**KIRKLEES METROPOLITAN COUNCIL
INVESTMENT & REGENERATION SERVICE**

DELEGATED DECISION TO DETERMINE PLANNING APPLICATIONS

Reference No: 2021/62/90219/W

Description: Erection of extensions and alterations to garage create dwelling forming annex accommodation associated with 5, Park Riding, Northgate, Honley, Holmfirth, HD9 6QL

Drawing Title
Proposed Plans

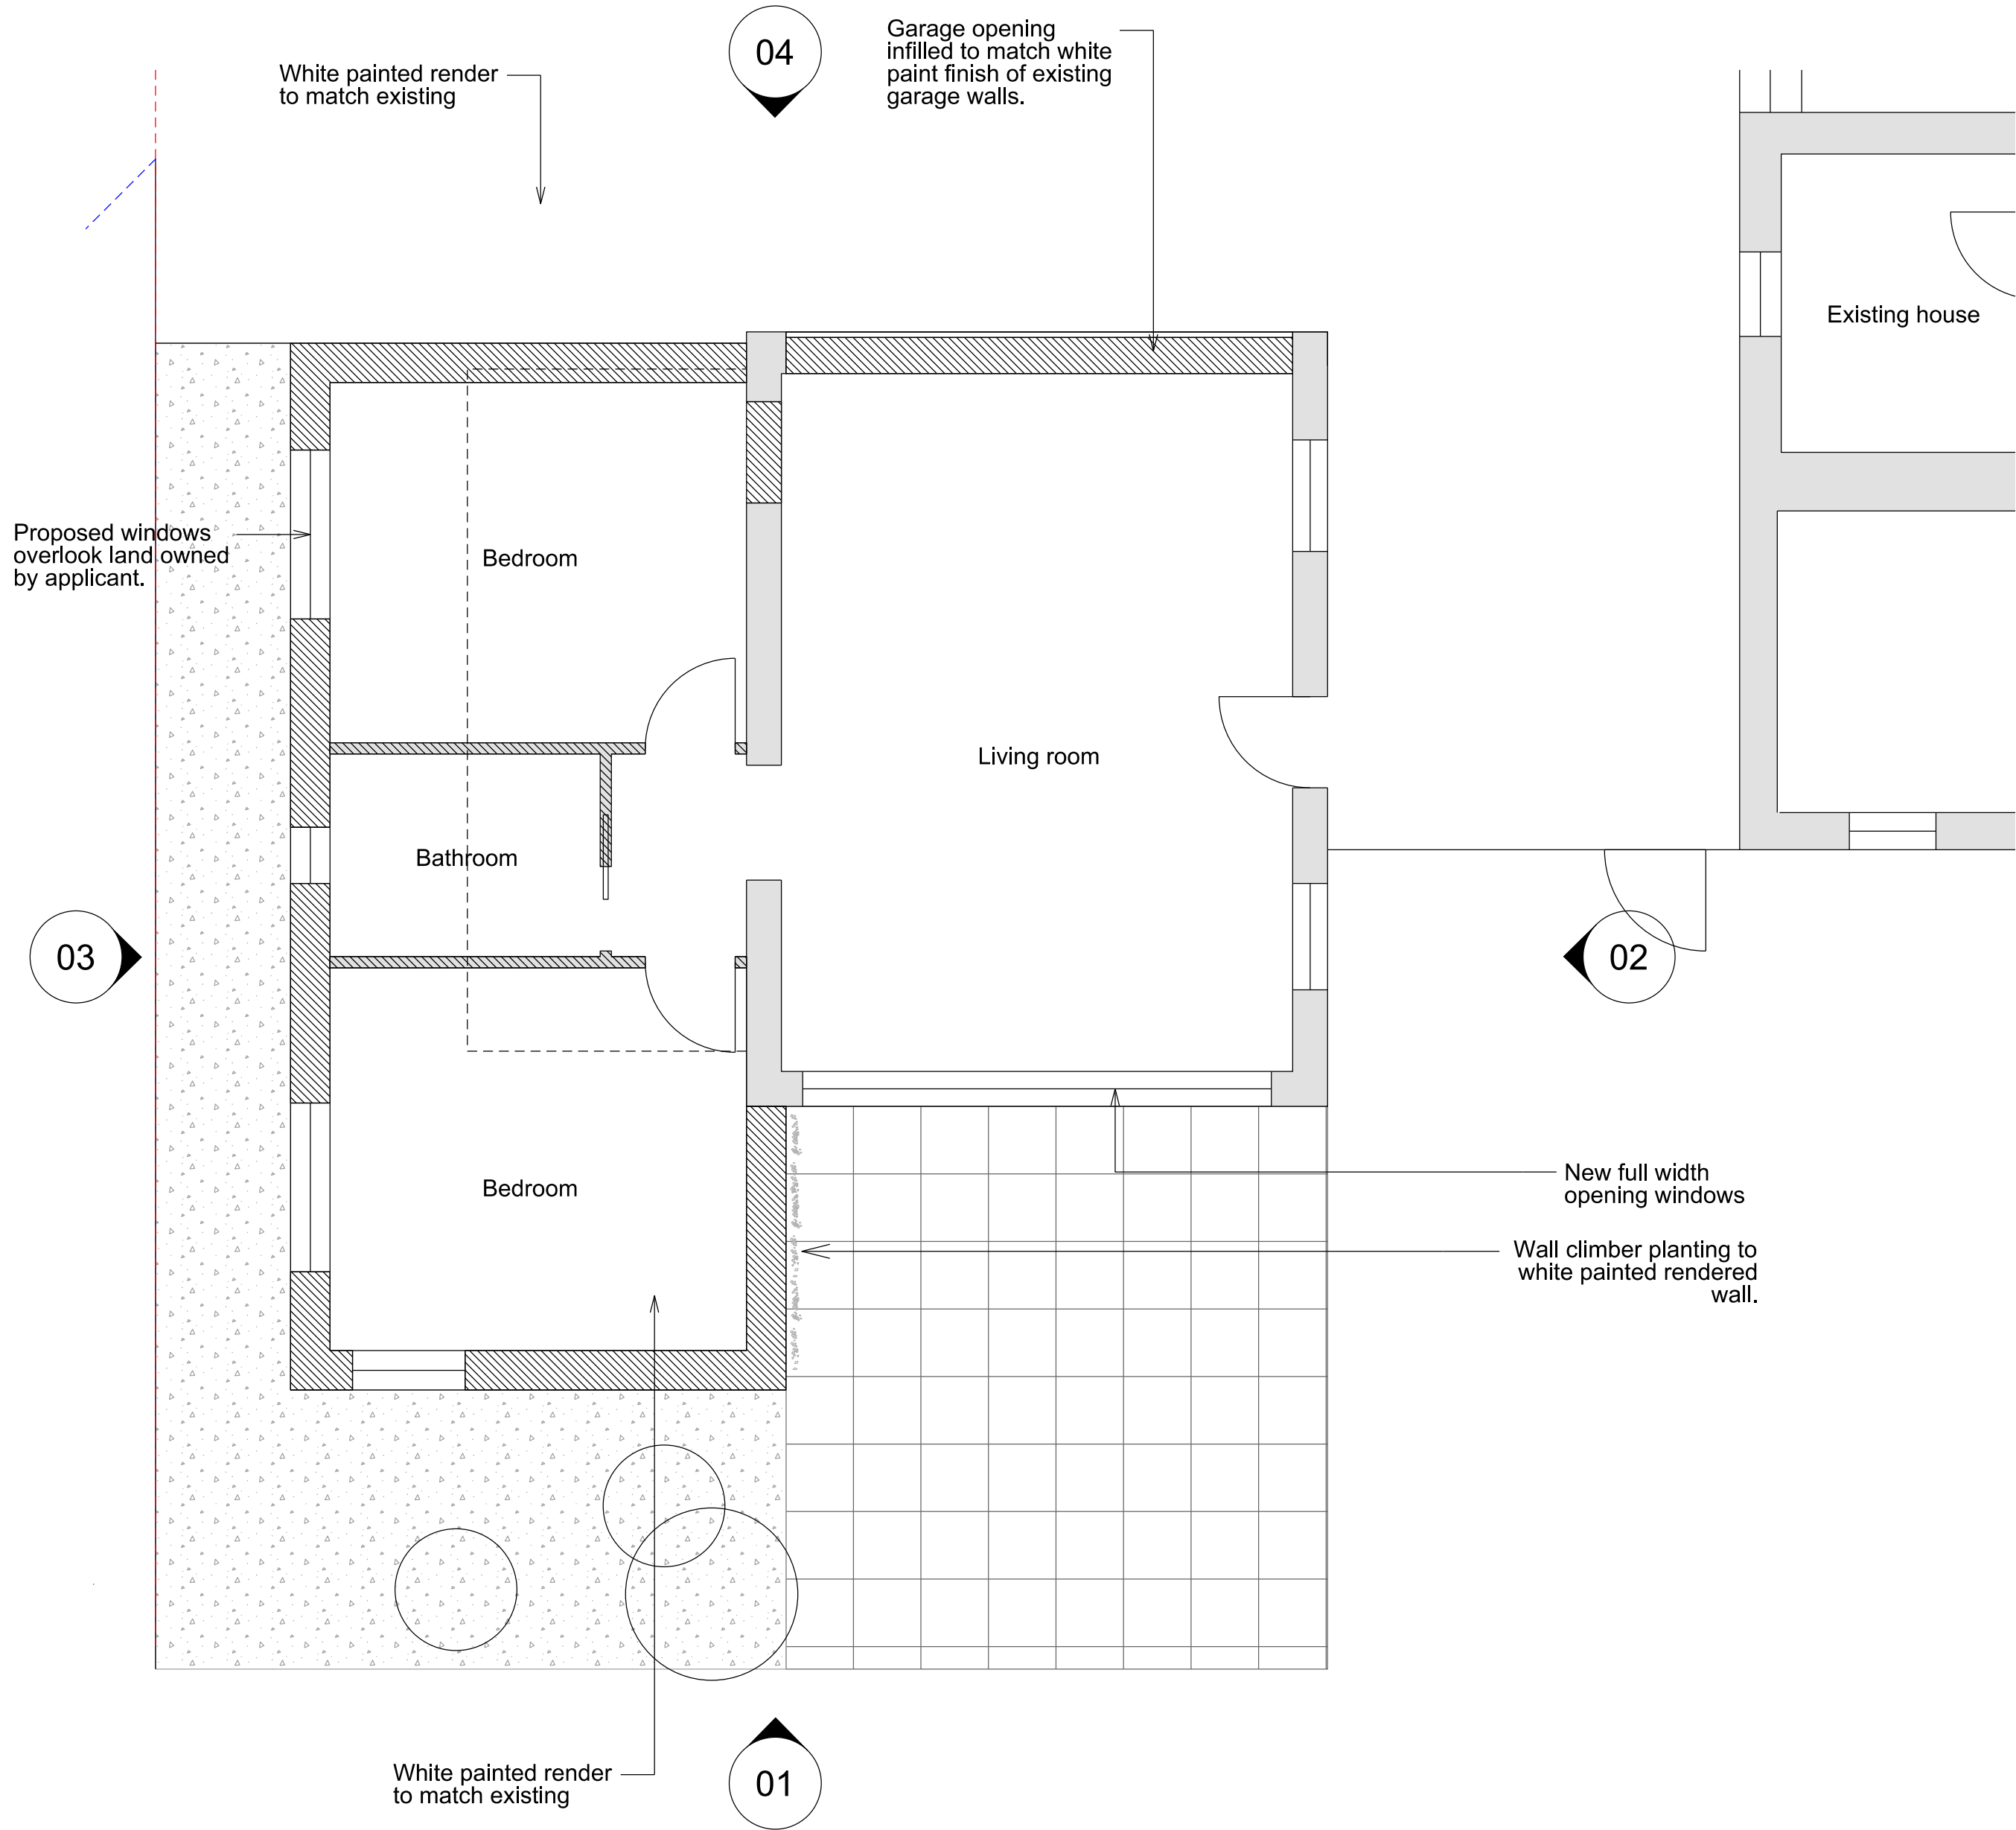
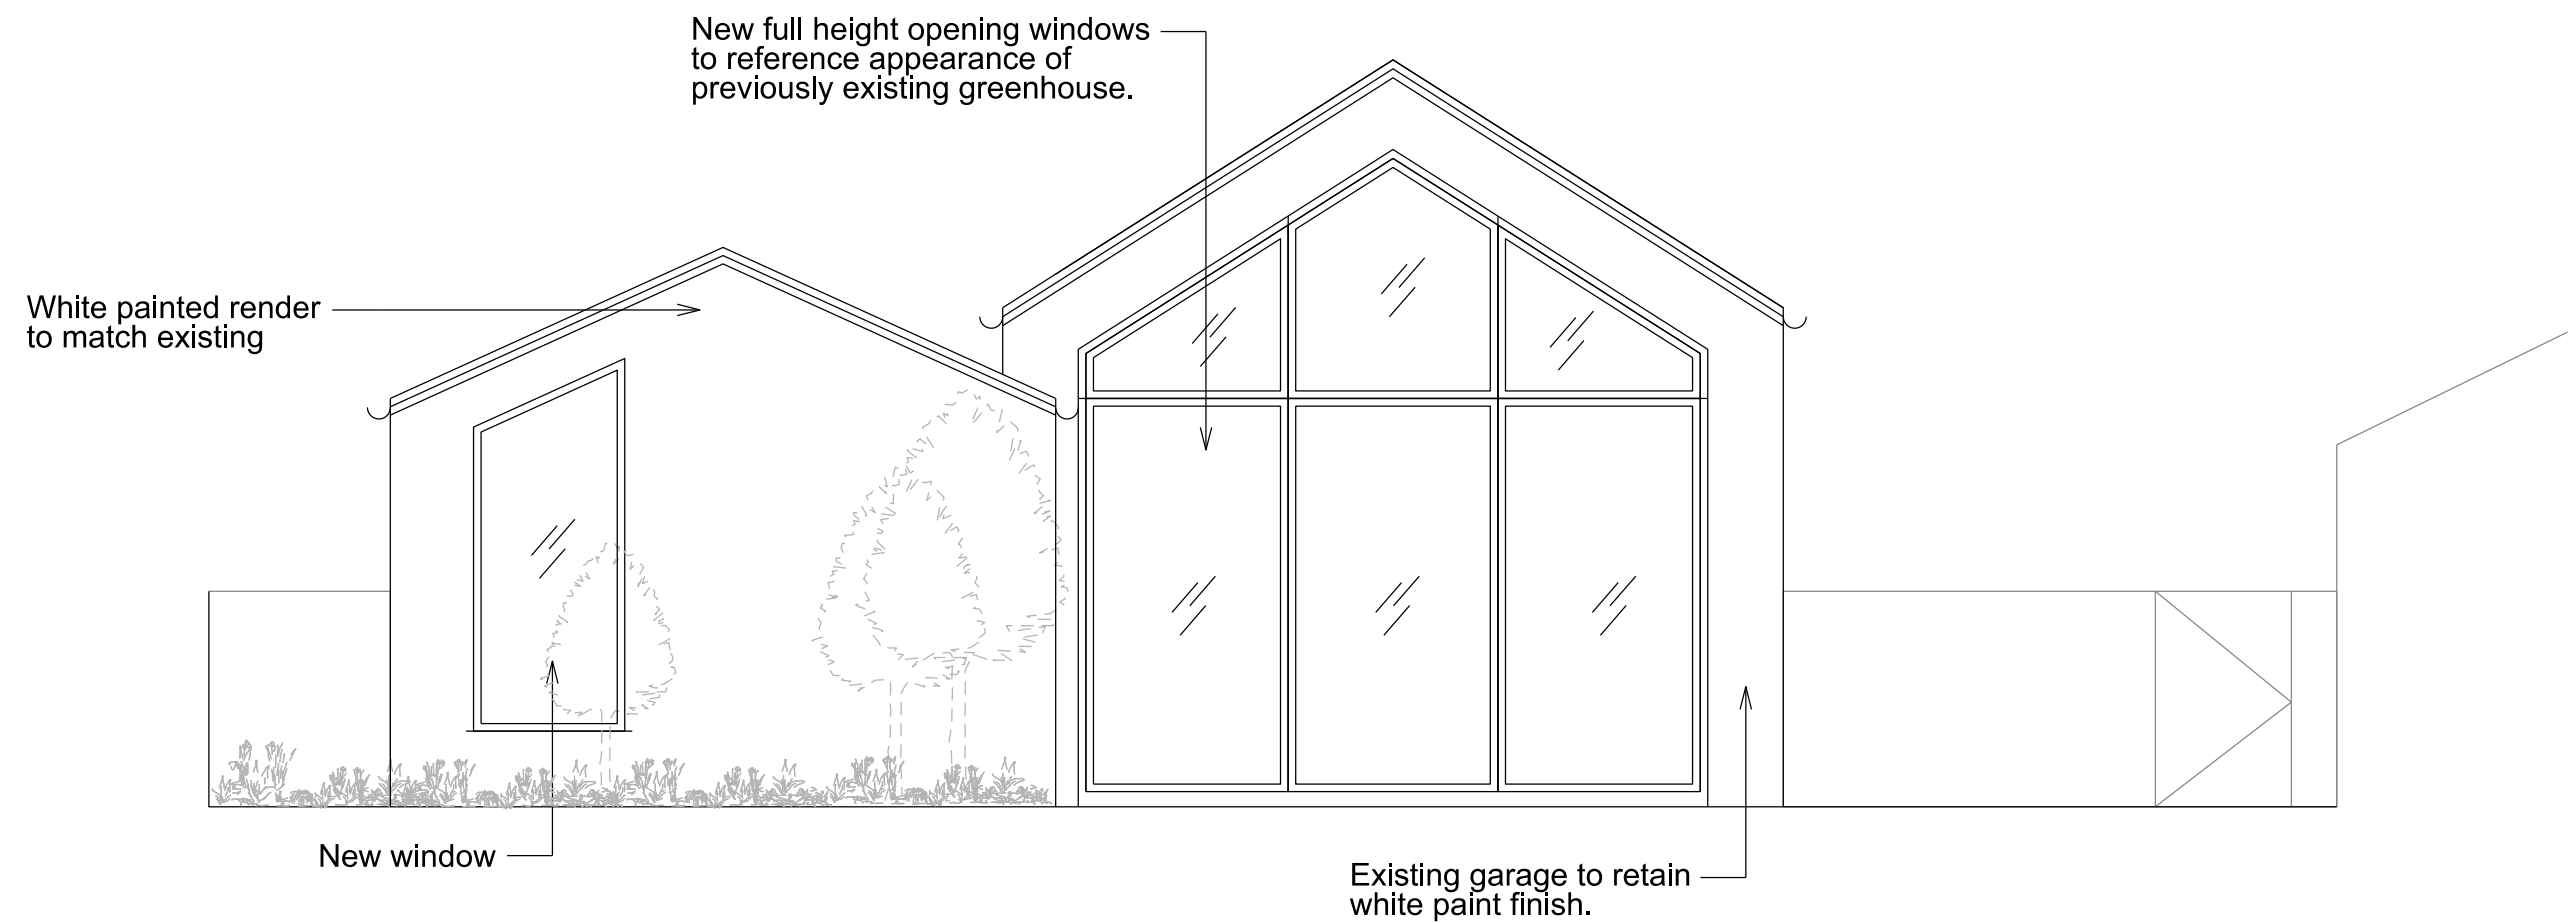
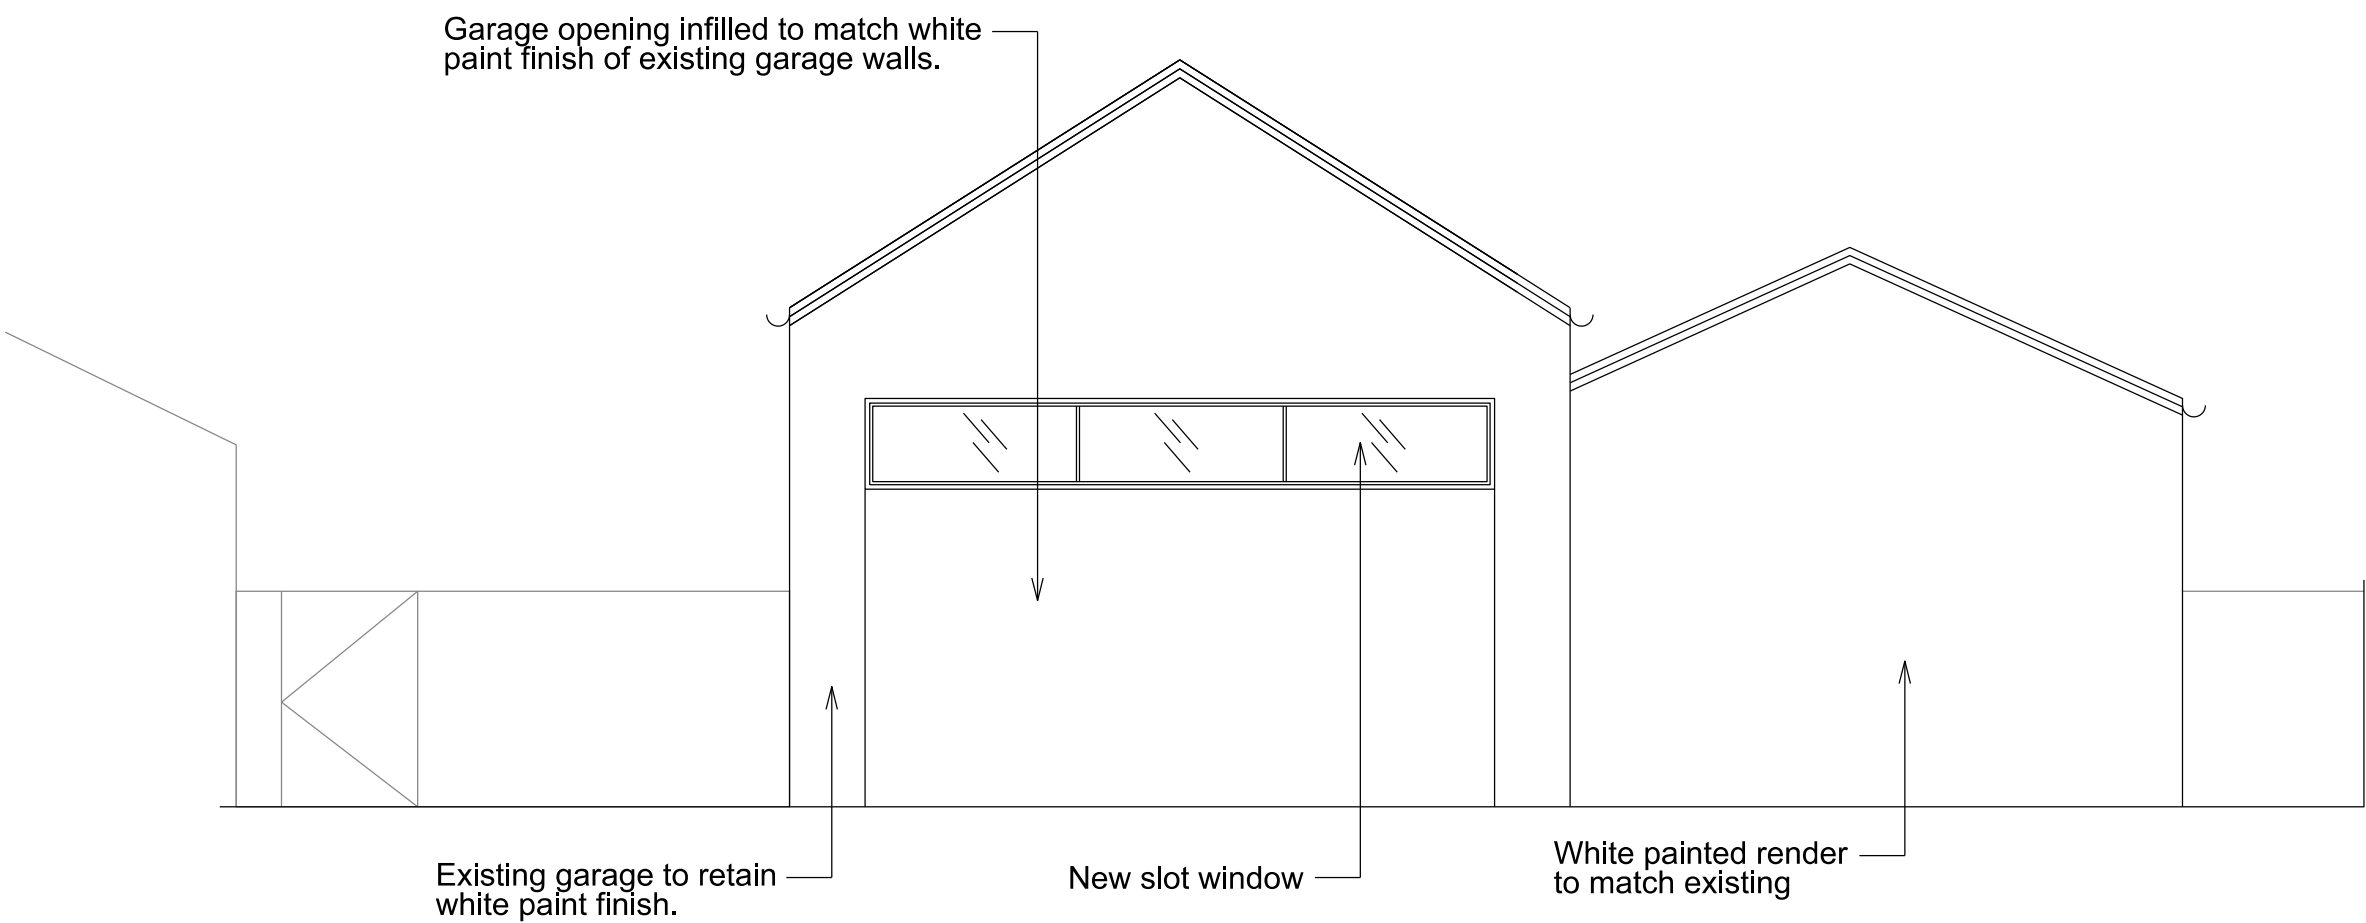
Amendments have been sought to amend the red line boundary of the application site due to concerns over land ownership. Additional alterations were also requested to the submitted plans to reduce the overall scale and size of the proposed annex and remove some of the proposed hardstanding to the side of the building in the interests of visual amenity and the impact on the openness of the Green Belt.

- The proposed annex would have a footprint nearly as large as that of the applicant's main house. This would alter the scale, character, and balance of building within the whole of the Park Riding curtilage and would impact on the visual amenity of the area;

- The design and materials proposed are not in keeping with the character of the adjacent listed building in a conservation area;

Further amendments were made to reduce the overall scale and size of the annex; however, re-consultation was not undertaken on this issue as it bore no relationship with landownership or car parking issues, it also sought a reduction in massing which in turn reduced concerns for visual and residential amenity. It is in officer's opinion that no third party would be negatively impacted by the decision not to re-consult in this instance.

The scale of additions to the property, combined with the design of the extension which is single storey in scale, has a ridge height set down from the main body of the garage and the fact that it replaces a former addition to the garage is considered to sufficiently demonstrate that the building would not represent a disproportionate addition to the property. Furthermore, it is noted that a greenhouse that was previously attached to the garage until very recently and evident on the site photographs has been removed to facilitate the extension, further reducing built form at the site. Turning specifically to the design of the proposal, it would lead to the garage have a generally contemporary feel with large sections of glazing. Such an approach is not opposed subject to an assessment on its impact on the adjacent listed building which is undertaken below. The addition to the garage is considered to be clearly read as a subservient addition to the original building given the

ridge height is set down and the slight set back from the front elevation. The use of matching materials would help it to harmonise with the existing building. The design of the extension is therefore considered to be acceptable.
